REPLY TO CLIENT'S RESPONSE REPORT

LAND AT KINGS CLOSE YAPTON

ROAD SAFETY AUDIT STAGE 1
JUNE 2014

SUPPLEMENTARY

drawing no. 13020-03

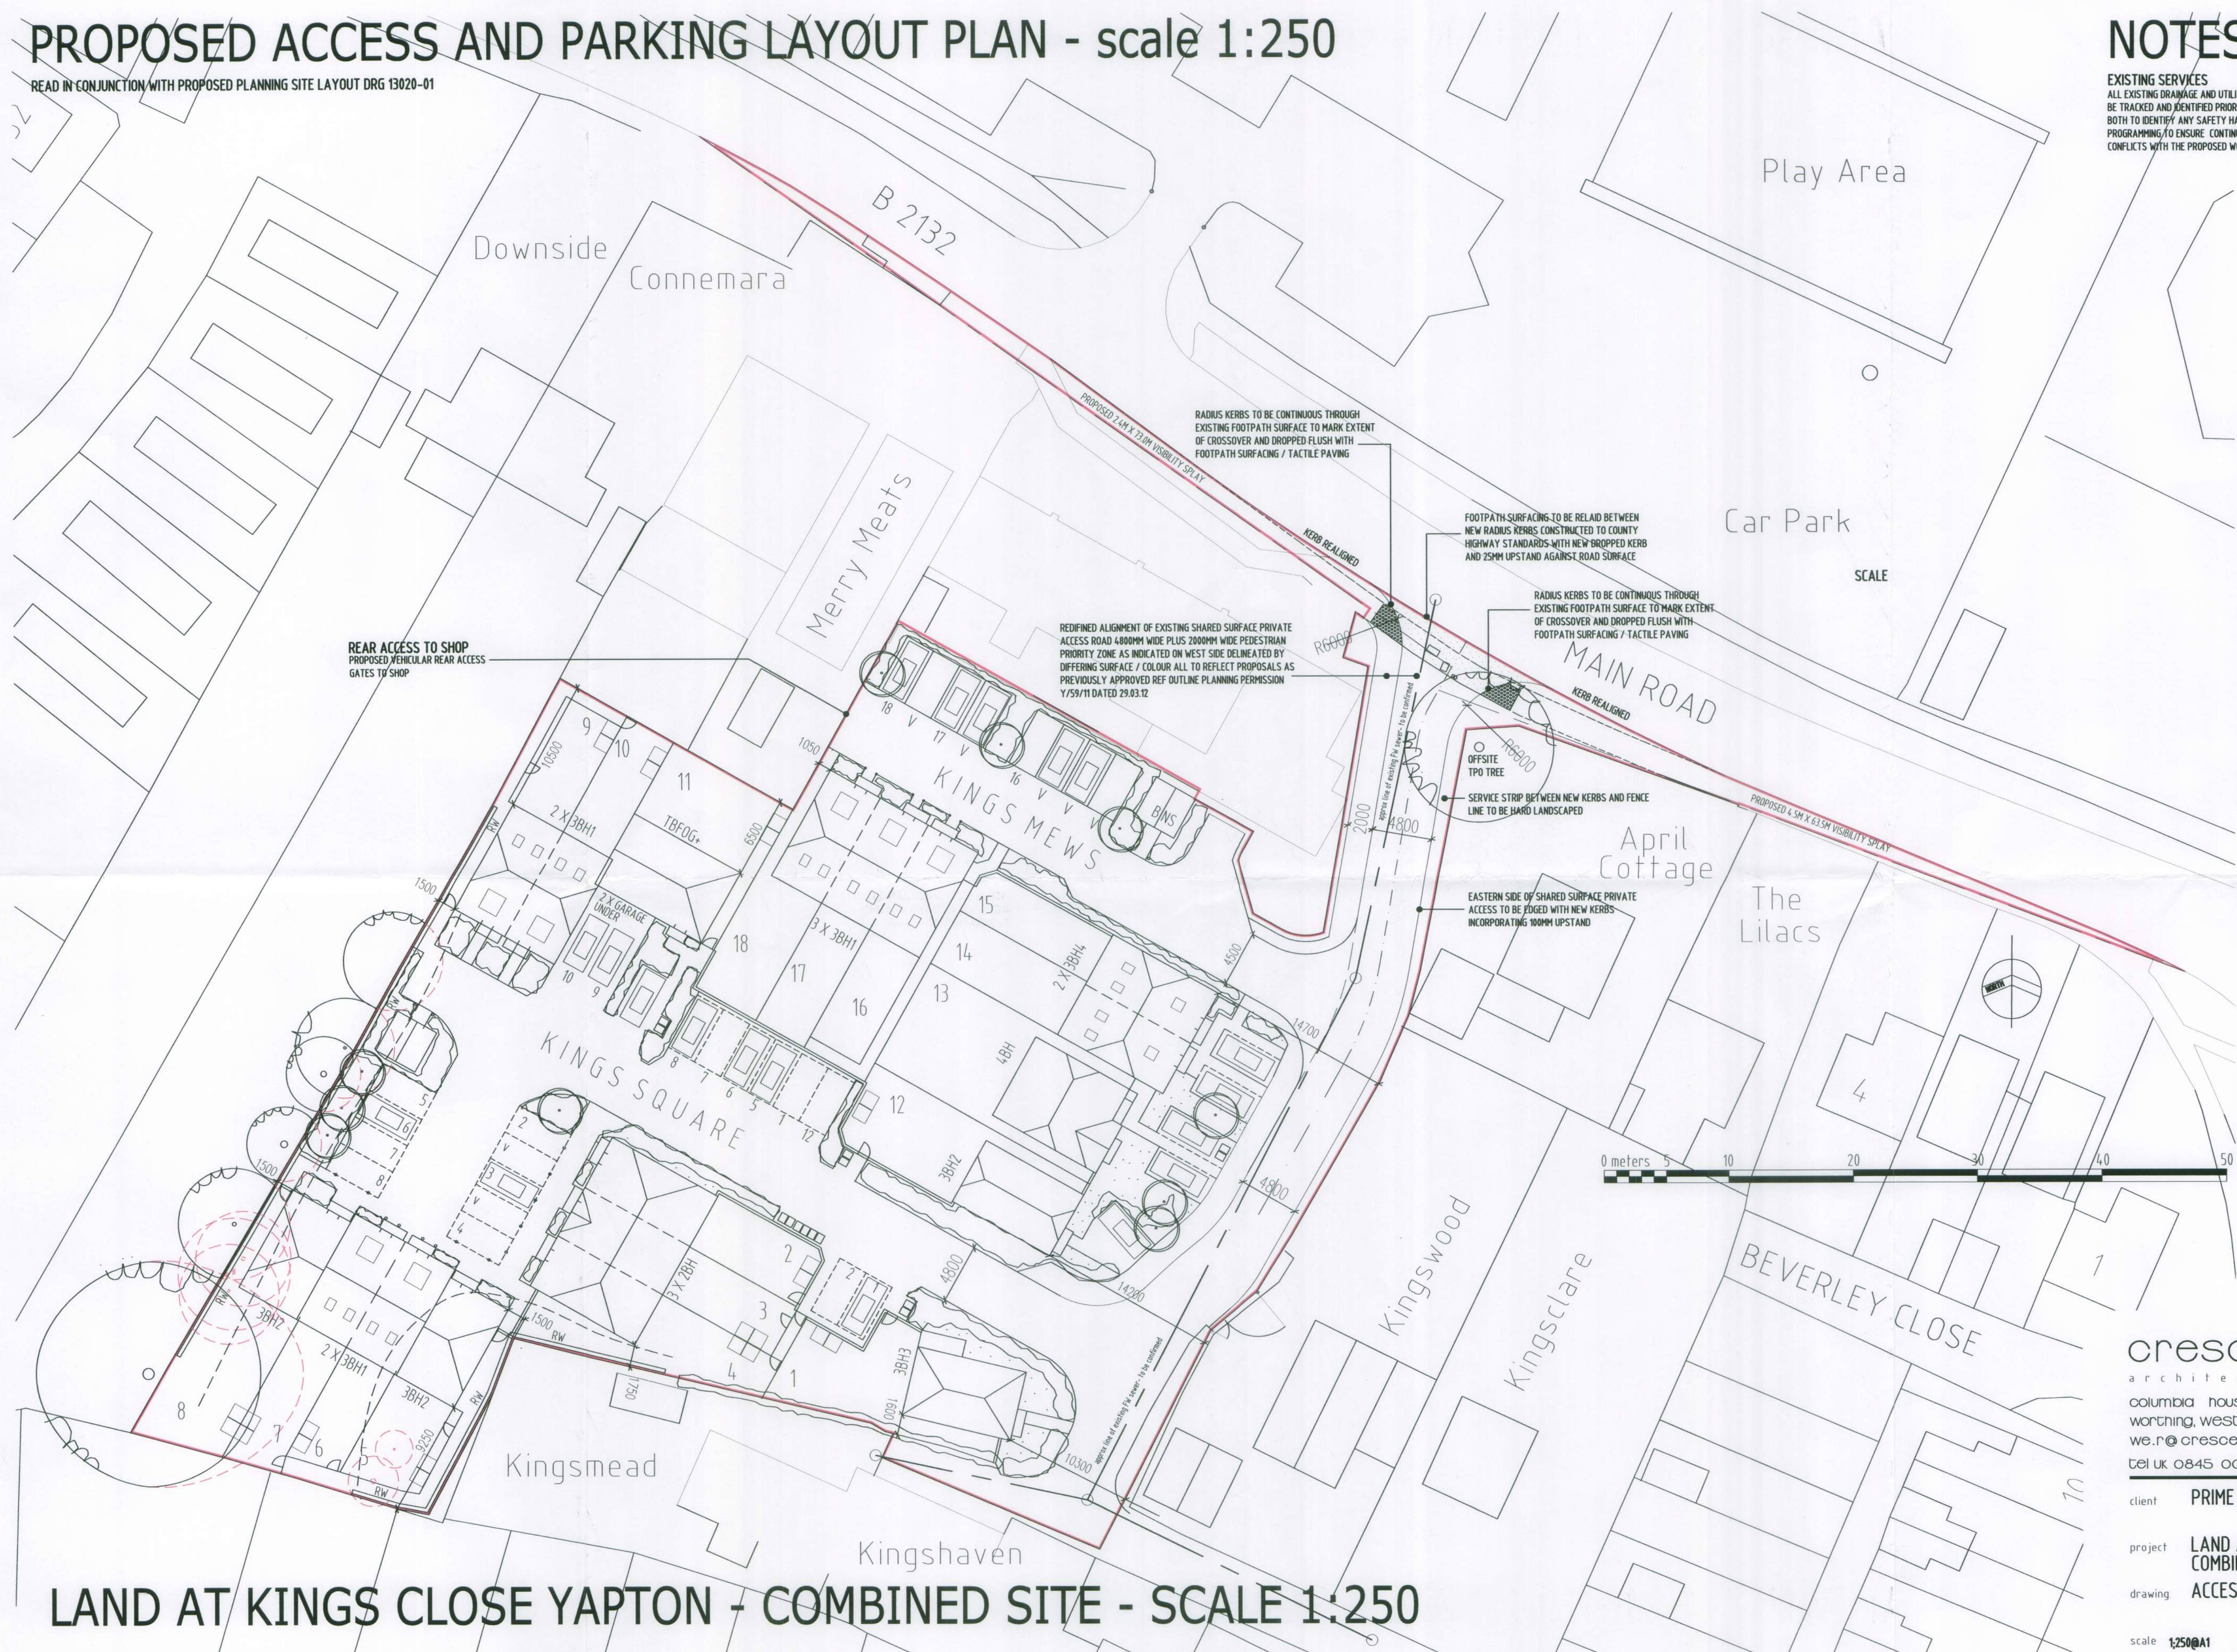
2.2	Location: At the entrance to Kings Close Summary: lack of definition of the service margin may result in accidents Drawing No. 13020-03 shows a 2.0m wide service margin with a footway surface extended from the public highway for a short distance to meet the low level ground cover of the service margin. It is not clear whether the footway surface is level to the shared use area of Kings Close or level to the public highway footway. If the footway surface is at the same level of the Kings Close shared use surface blind of partially sighted pedestrians may become disoriented and pedestrian/vehicle conflicts may occur.	It is recommended that level differences should be provided to the standards of the Inclusive Mobility Unit to assist blind pedestrians.	The short length of footway surface referred to within the audit document is intended as a service margin / raised pedestrian walkway as part of the private road extended from the convenience store forecourt area both raised and distinct in colour from the shared surface itself. Following a review of the recent coop extension on site the walkway area adjacent the shared surface at the access has been extended in context with the adjacent building slightly further into the site. The outline planning application drawings have been revised noting that a level differentiation is to be included as recommended in the stage 1 audit together with a visual distinction between the	This answers the issue raised and would remove the problem. This should be checked at the Stage 2 RSA

Para No.	Observation/Problem	Recommendations	Designer's/Clients's Response	Safety Audit Team's Response
			walkway, the shared surface and other carriageway surfaces. A larger rumble strip has also been indicated to mark the change of circumstances to drivers at the crossover.

drg no 13020-02REV B scale 1:250 @ A3

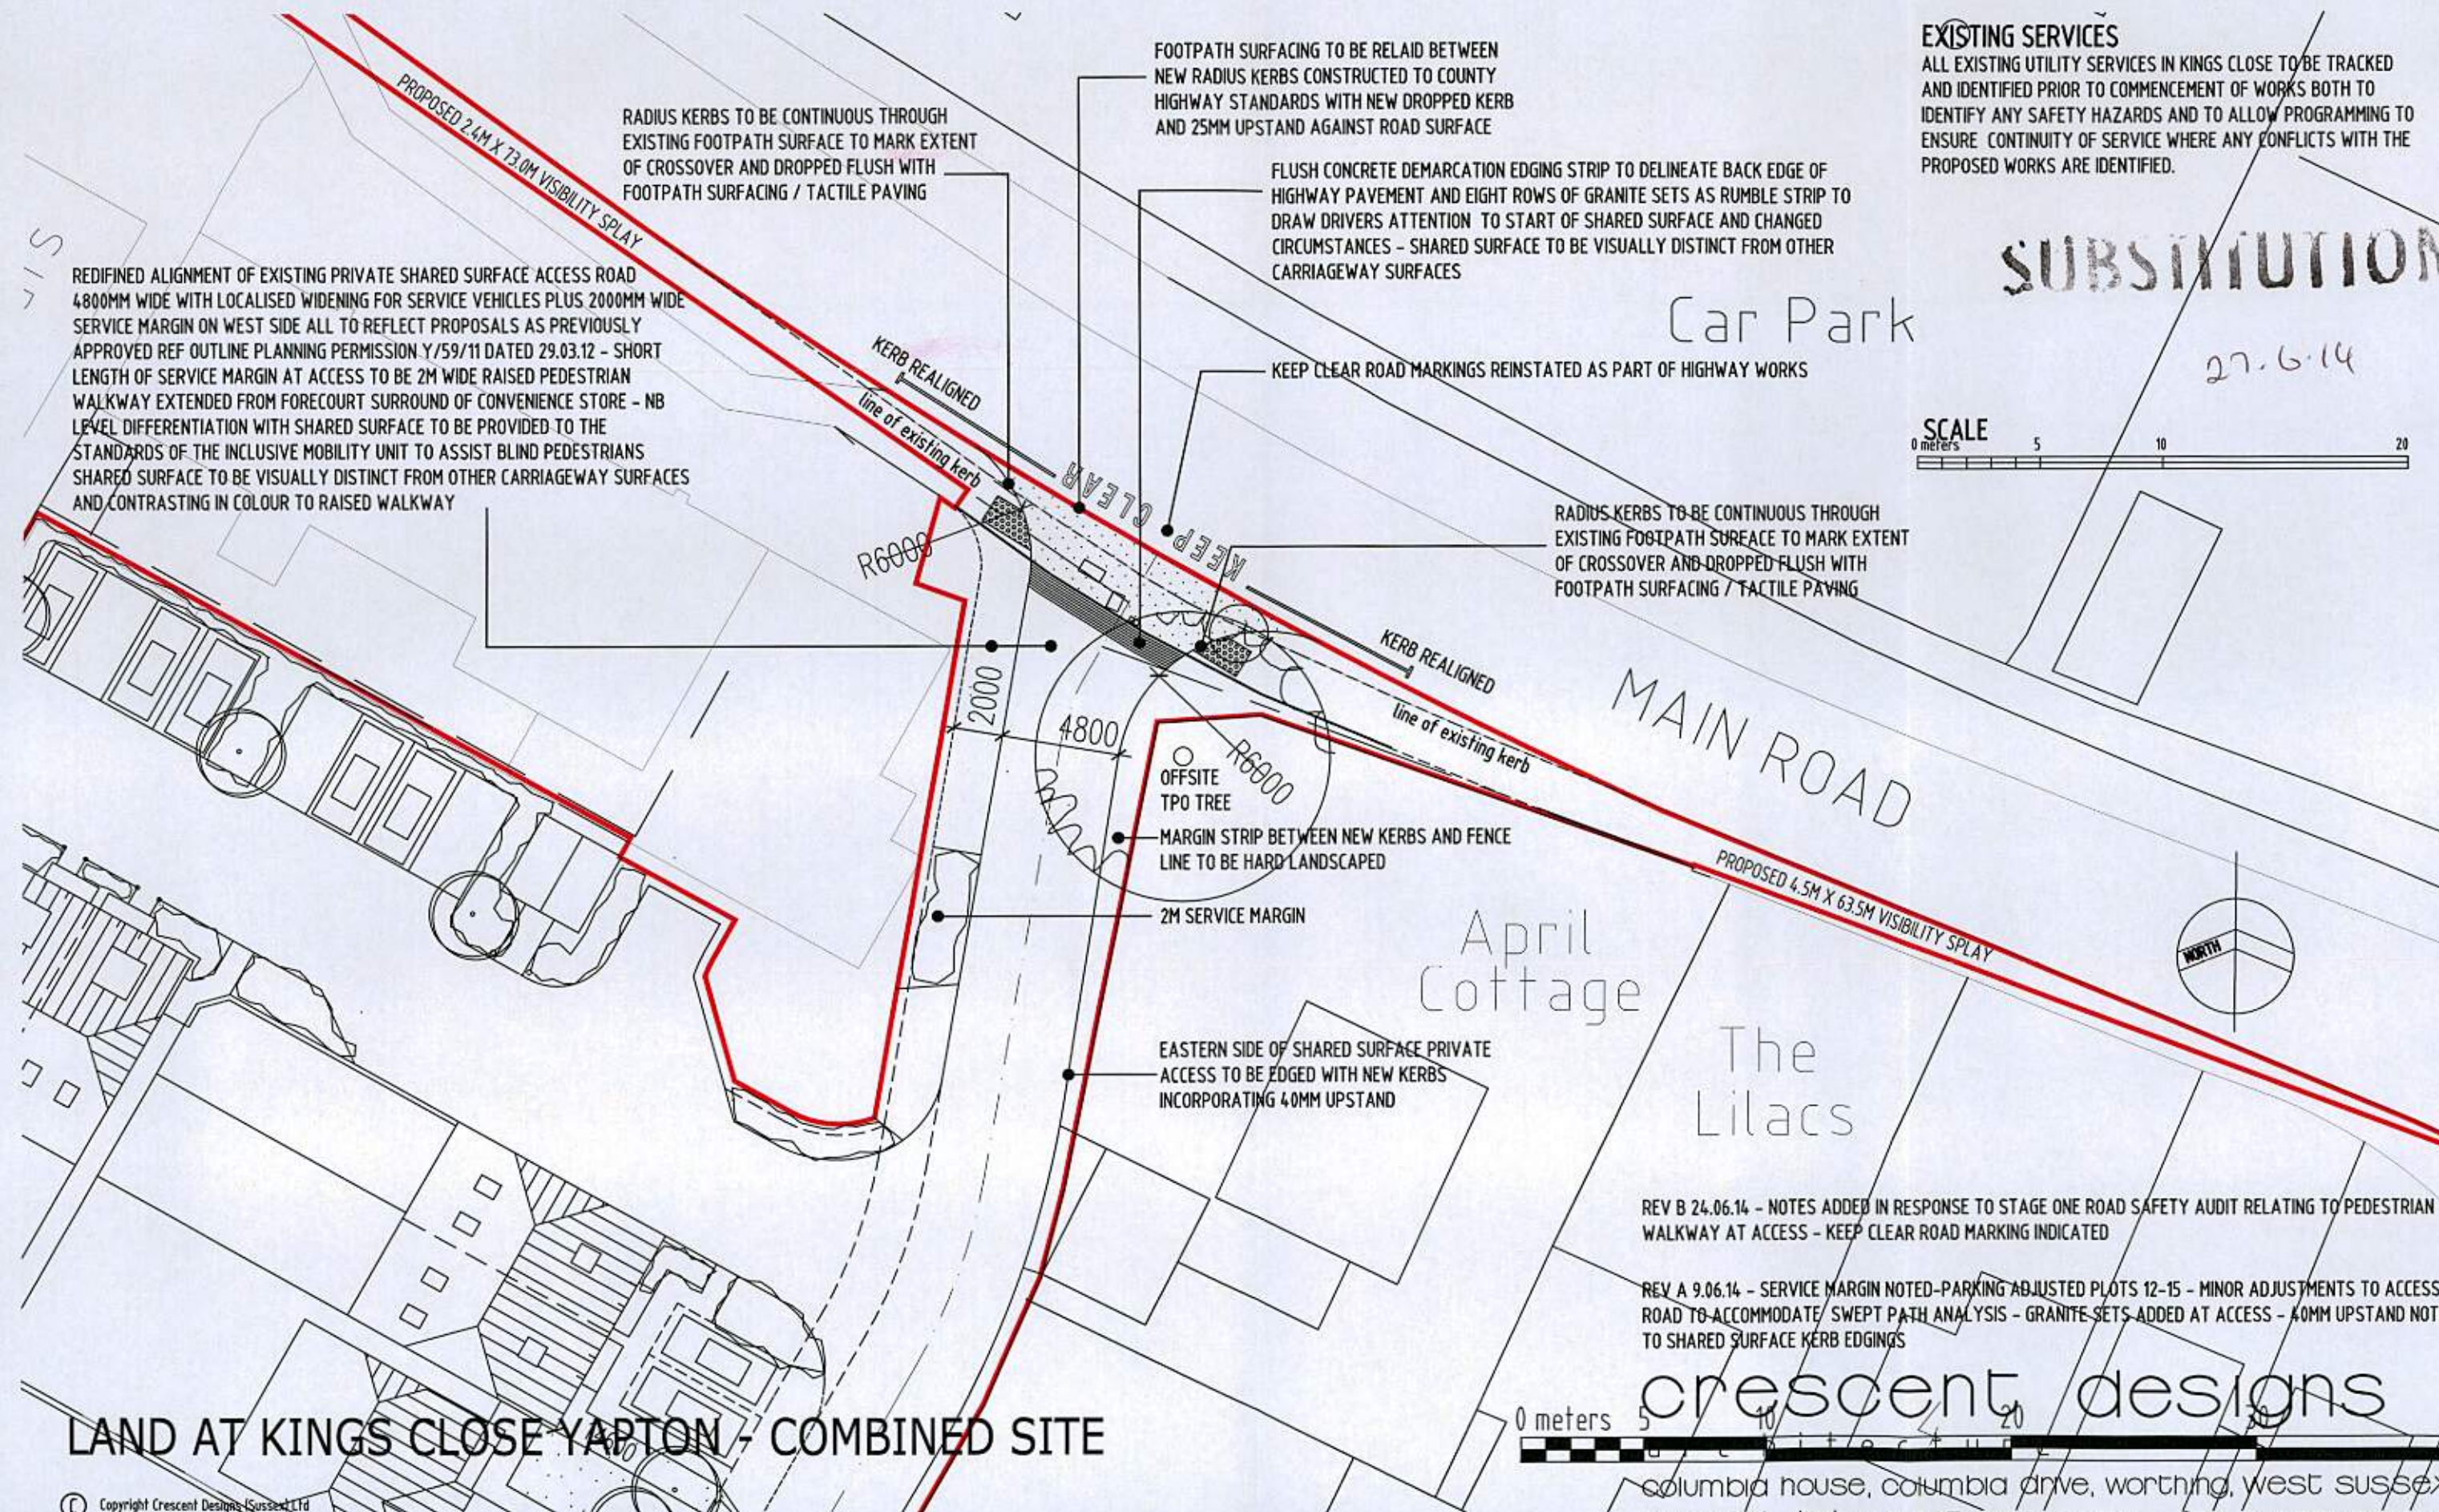
Para No.	Observation/Problem	Recommendations	Designer's/Clients's Response	Safety Audit Team's Response
2.1	Location: At the Main Road/Kings Close junction Summary: lack of loading facilities may result in accidents At present it is not clear how the Co-operative Store is serviced, although 'Keep Clear' carriageway markings are across the junction of Kings Close and it is assumed that HGVs are parked on the carriageway of Main Road, possibly across Kings Close while delivering. The reduction of the width of Main Road would present a danger for other road users if HGVs stood on the public highway and may result in vehicle/vehicle conflicts	It is recommended that the loading arrangements at the junction of Main Road/Kings Close are reviewed.	Servicing and deliveries to the convenience store are an ongoing and existing highway management matter. Maintaining the "keep clear" carriageway markings at the entrance to Kings Close and the presence of the parking layby to the west would suggest a deterrent to HGV's parking on the carriageway in the immediate vicinity of the junction of Kings Close with Main Road. The outline planning application drawings have been revised to indicate that the "keep clear" road markings at the access to Kings Close are maintained as part of the highway works.	Acknowledged
